<input type="checkbox"/> Sidewalk Waiver (Form V2)		
<b>SITE PLANS</b>		<input type="checkbox"/> Waiver to IDO (Form V2)	<b>APPEAL</b>
<input checked="" type="checkbox"/> DRB Site Plan (Form P2)	<input type="checkbox"/> Waiver to DPM (Form V2)	<input type="checkbox"/> Decision of DRB (Form A)	
<b>BRIEF DESCRIPTION OF REQUEST</b>			
Apartment complex development

**RE: Sonata Unit 4 Trails Apartments  
Tracts 1, 2, and 3, The Trails Unit 4  
Second DRB Submittal**

RESPEC, agent for Sonata Trails, LLC, owner of the above referenced property, is requesting approval from the Development Review Board (DRB) on this Site Development Plan submitted for your consideration. This is the second submittal to the DRB for this project. The first hearing was held on June 3, 2020. Below is a response to comments received at the first DRB meeting.

WATER CONSTRUCTION NOTES

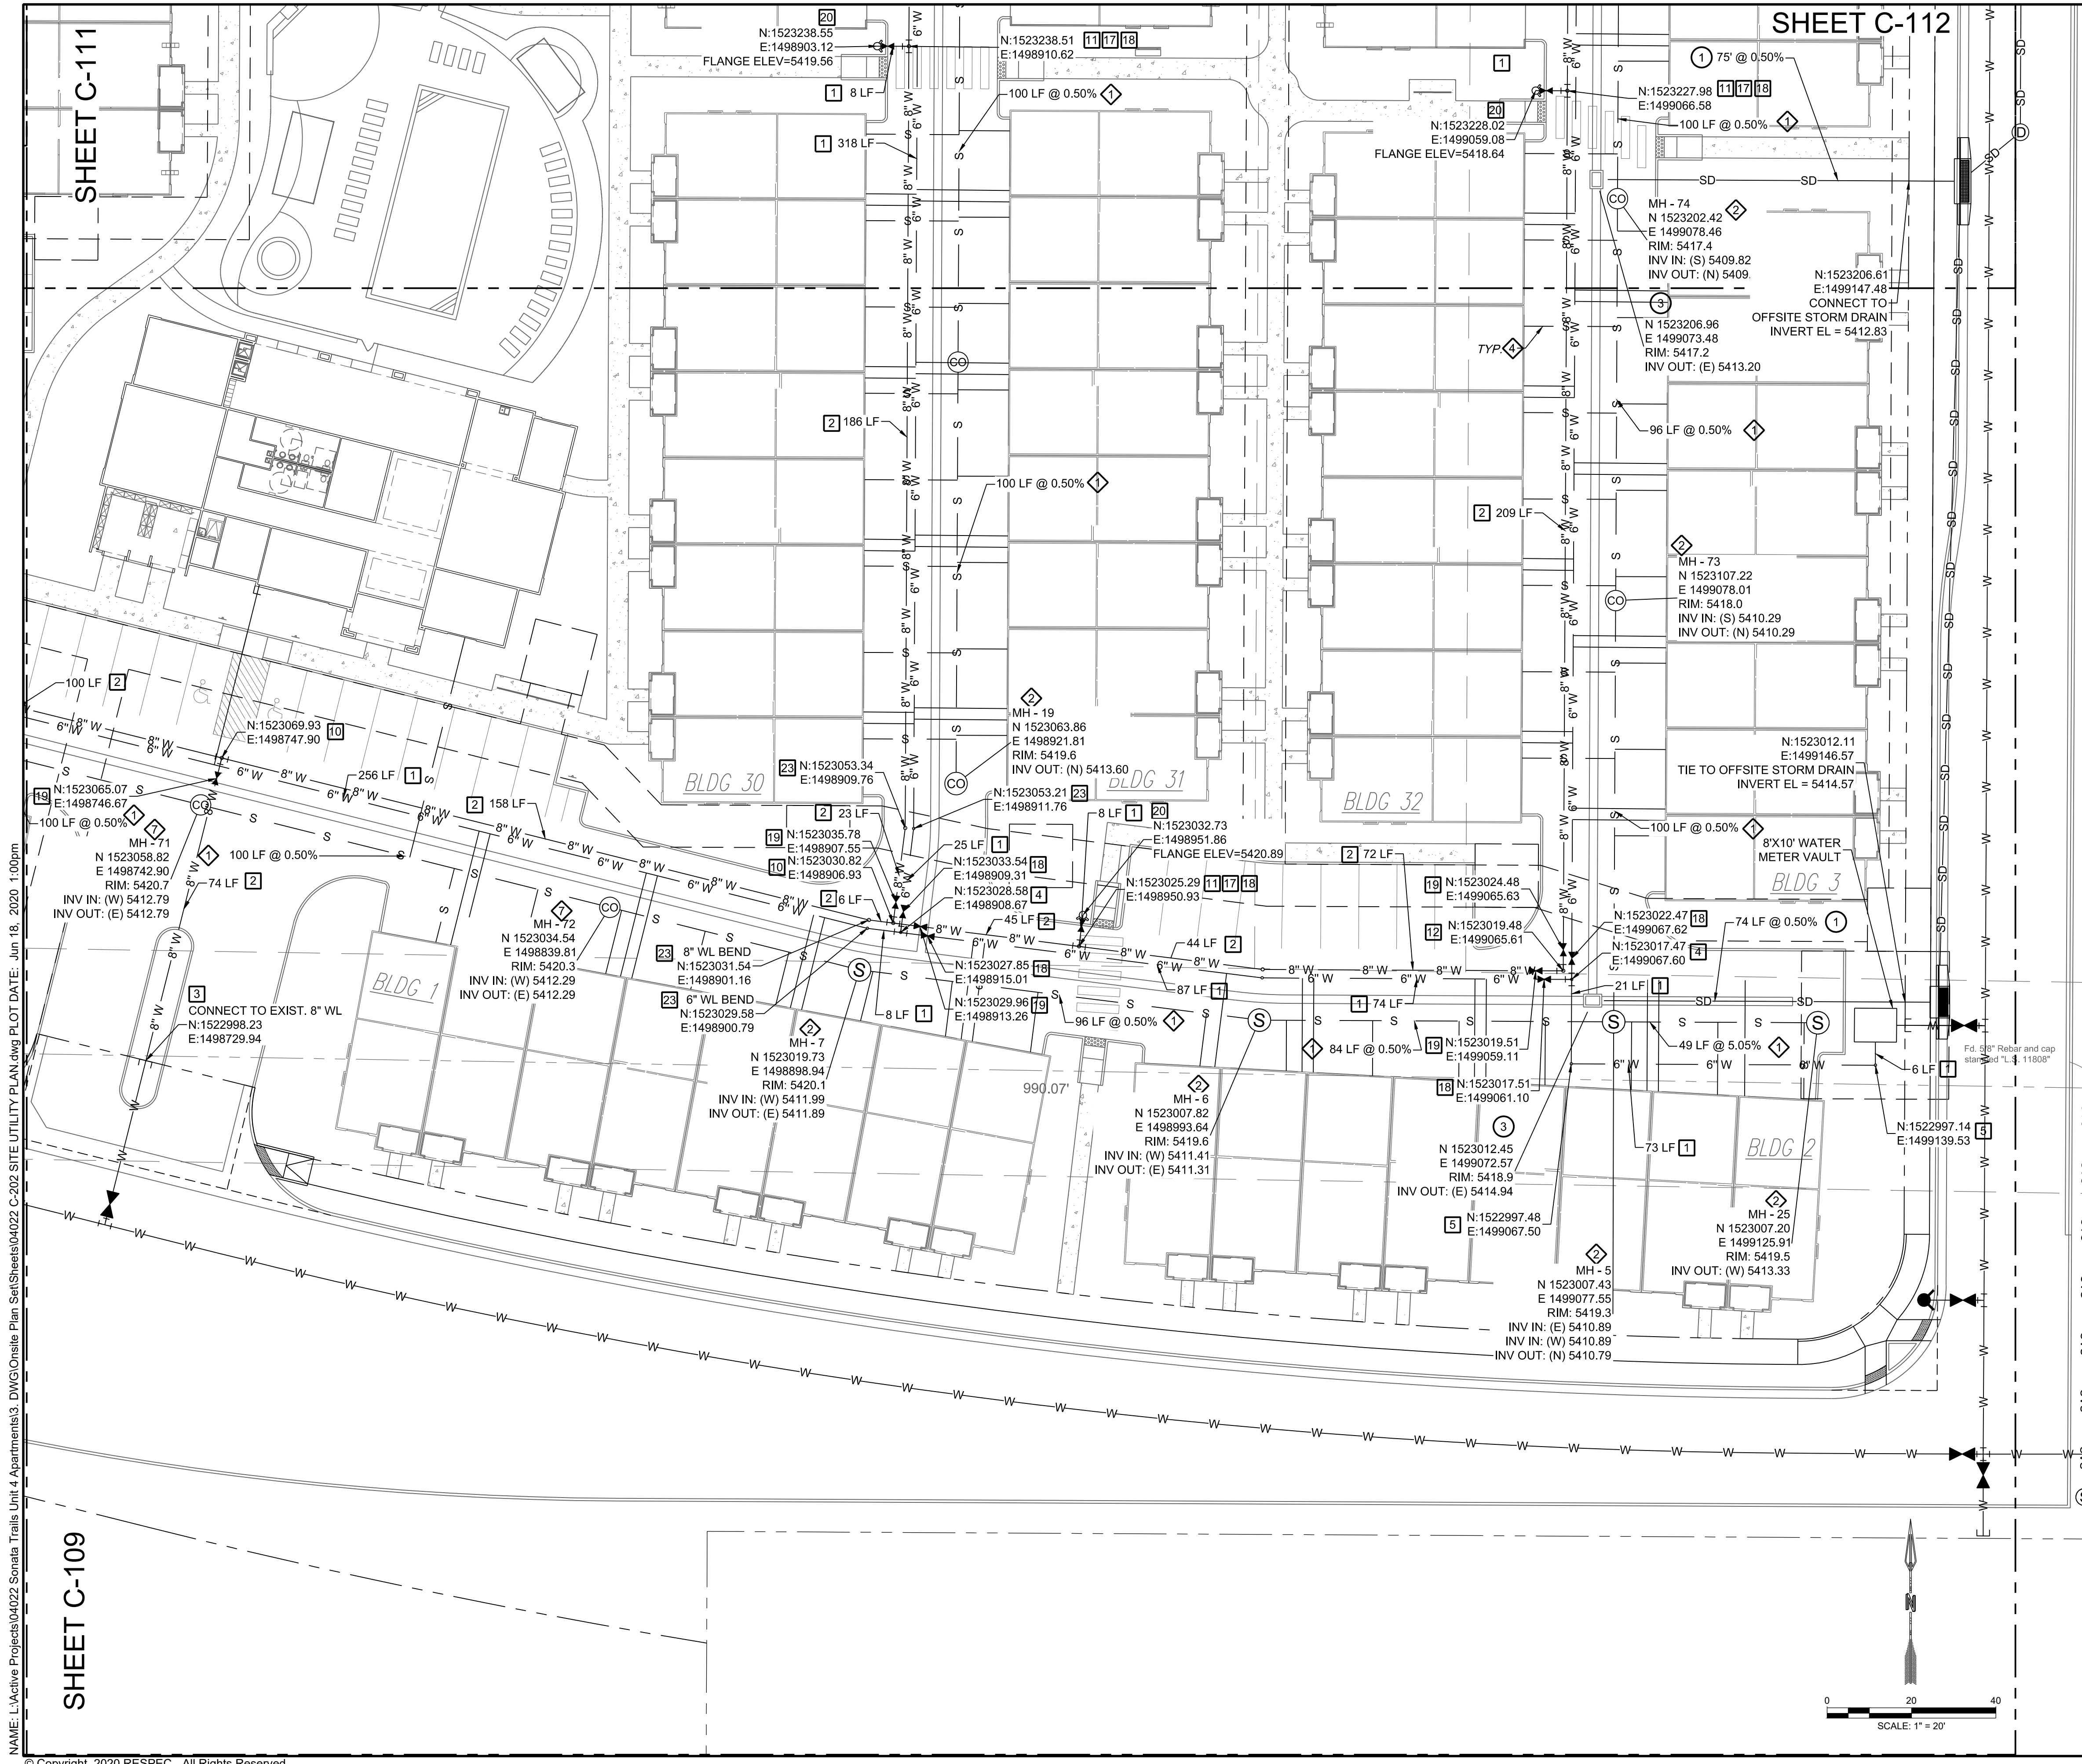
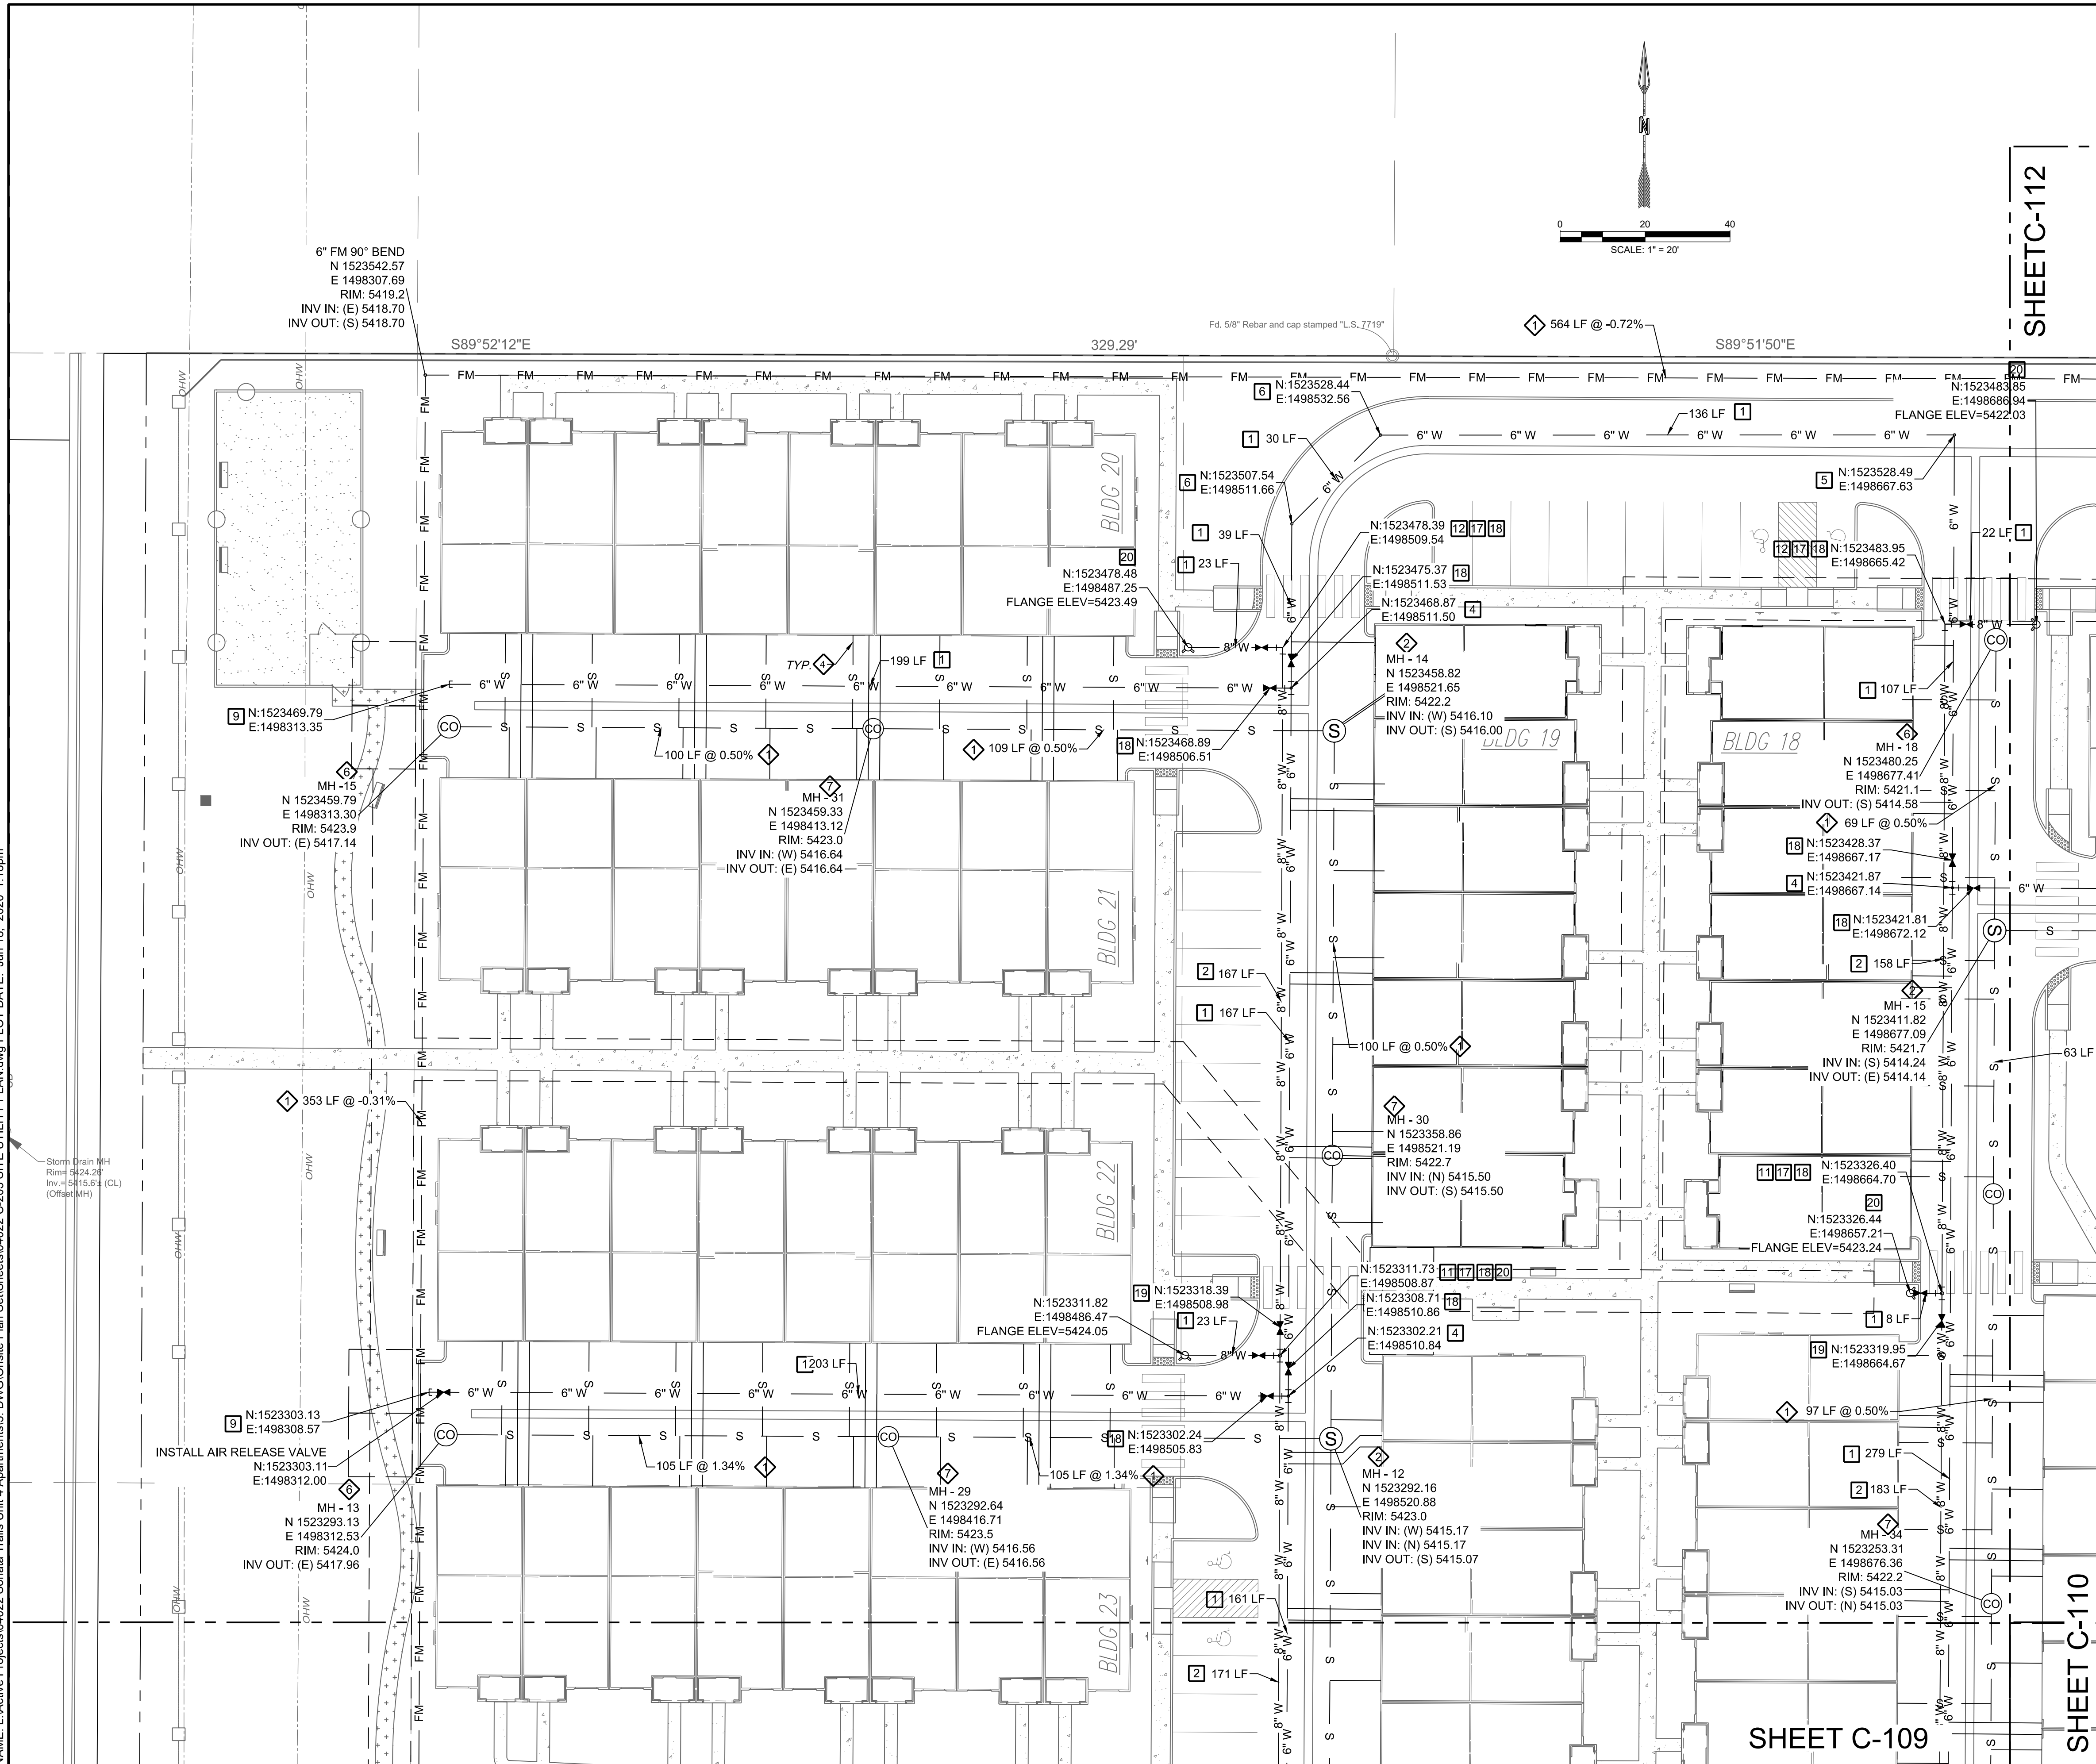
3. Utility Plan
    - a. A meter is shown for each unit. This is not consistent with a previous proposal for a previous request for availability statement which included master meters for the entire development. The proposal for individual meters for each unit (which is not consistent with the calculation for UECs in the Rate Ordinance) appears to be significantly more costly.

- i. The onsite public waterline can be minimized depending on the outcome of metered service locations. The apartment complex can be served by either a master meter or a combination of meters to serve buildings.

- b. Coordination with the engineer is taking place to understand the best routing of sanitary sewer for the subject development as it has an impact on the surrounding area. The alignment along Chatsworth Dr. is being researched to better understand a potential high point and ability for adjacent properties to discharge to this line.

- c. A proposed lift station is shown at the northwest corner of the subject development which ultimately discharges to proposed public gravity sanitary sewer along Treeline Ave.

- i. Considering the potential interim condition with the private lift station, the Utility Plan should show the phases.
      1. The interim use of a private lift station and the trigger to eliminate the private lift station and discharge to public sanitary sewer that flows to the proposed interceptor along Paseo Del Norte/Avenida De Jaimito

when it is available may need to be detailed in the development agreement.

- 1. Public sanitary sewer along Treeline Ave. that flows east is not shown on the Utility Plan.
- / If I remember correctly, a public sewer in Tree Line was not required in the previous serviceability statement. Will this be a requirement with the new serviceability letter? If so, who will this sewer serve? No change has been made to the utility sheets.

- e. Public waterline and sanitary sewer along the frontages of Treeline Ave. and Chatsworth Dr. are not shown to be proposed on the Utility Plan.
- / Public waterline and sewer are shown in Chatsworth Dr. and public waterline is shown in Tree Line Ave. See revised utility sheets.

- f. Label proposed lift station and onsite sanitary sewer as private (both force main and gravity sewer). Based on the determination of the onsite waterline, public waterline and private waterline shall be labeled as well.

- / The meters for each unit have been removed. We are proposing a master meter at the southeast corner of the development. See revised utility sheets.**

- / Detail has been added to demonstrate the phases for the private sanitary sewer. See revised utility sheets, specifically C-113.
  - d. Please confirm if the proposed manhole south of existing manhole C10302 can be eliminated by extending east directly from the existing manhole along Treeline Ave.

- / All utilities on-site will be private and all utilities within the right-of way will be public. See revised note 13 on sheet C-108.
